Application for a Non-Material Amendment Following a Grant of Planning Permission Town and Country Planning Act 1990 (as amended)

ERECTION OF SINGLE AND TWO STOREY SIDE AND REAR EXTENSION, NEW
PITCHED ROOF OVER EXISTING REAR EXTENSION

2025/62/90627/E

CLIENT: MR & MRS SWEATMAN
PROJECT: 37 PARK DRIVE
MIRFIELD
WF14 9NJ
DRAWING TITLE: AS PROPOSED
PROJECT REF: 2025-052
DRAWING NO: 200 REVISION: A
SCALE: AS SHOWN @ A1 DATE: JAN 2025

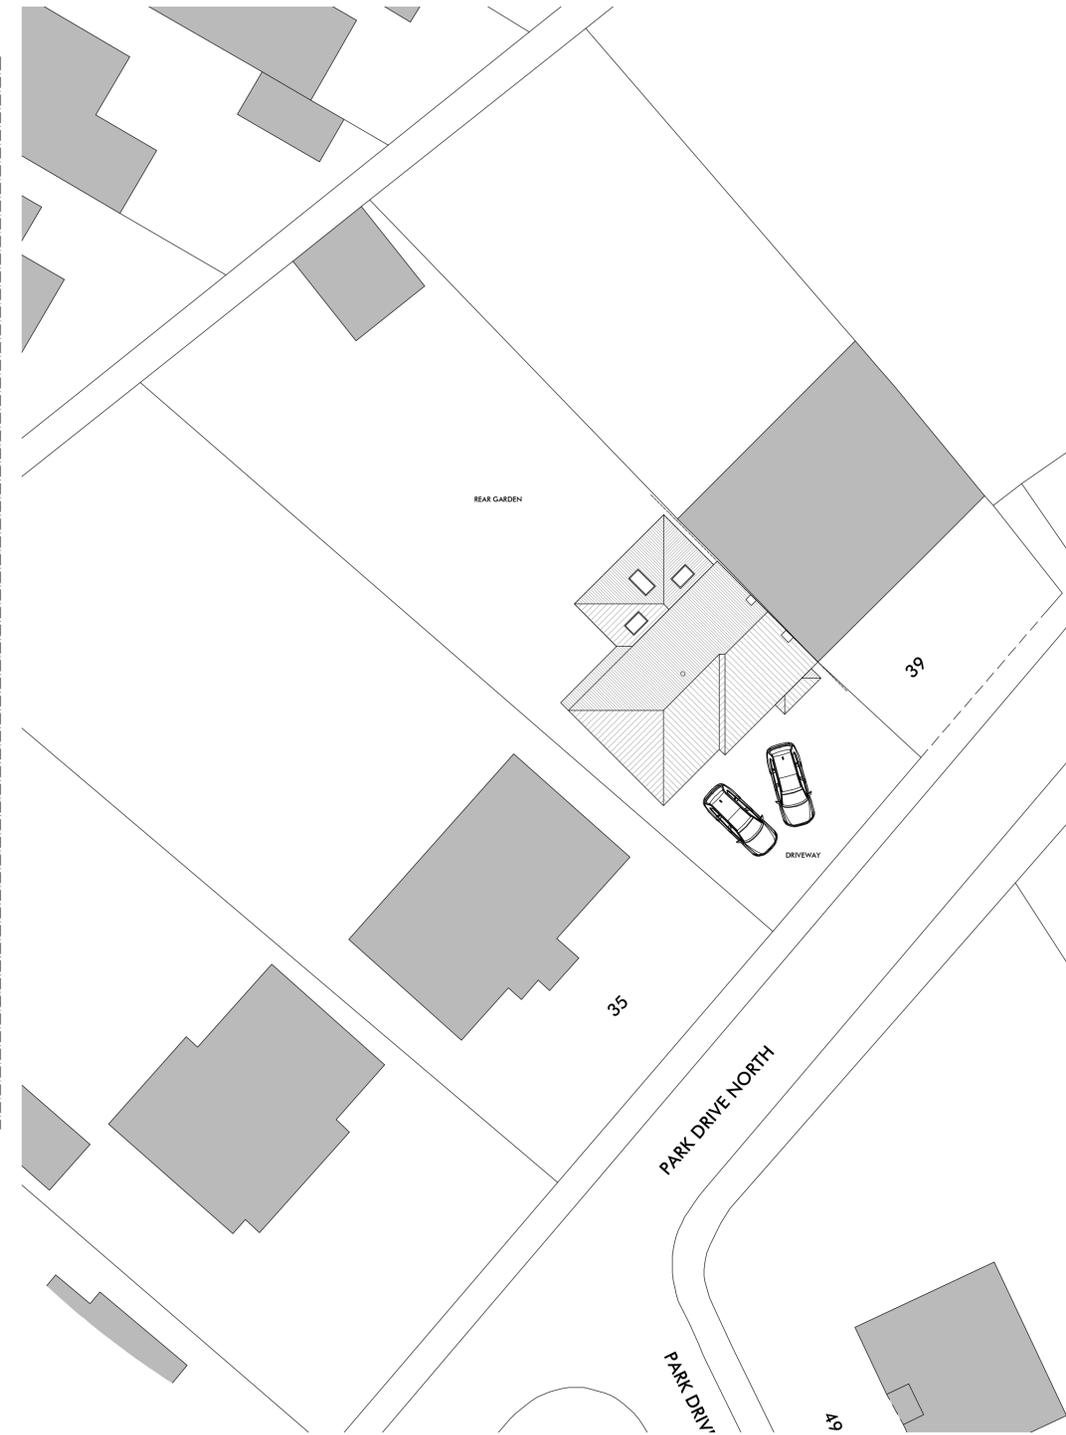
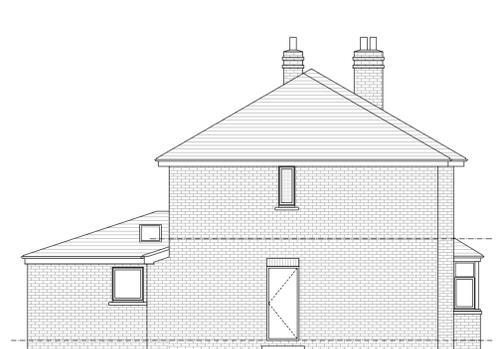
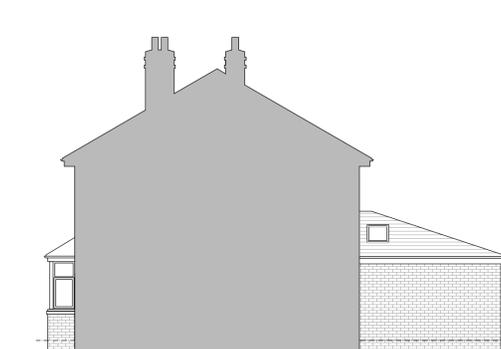
obscure glazed window added to first floor side elevation, ground floor side extension rear wall moved towards rear garden
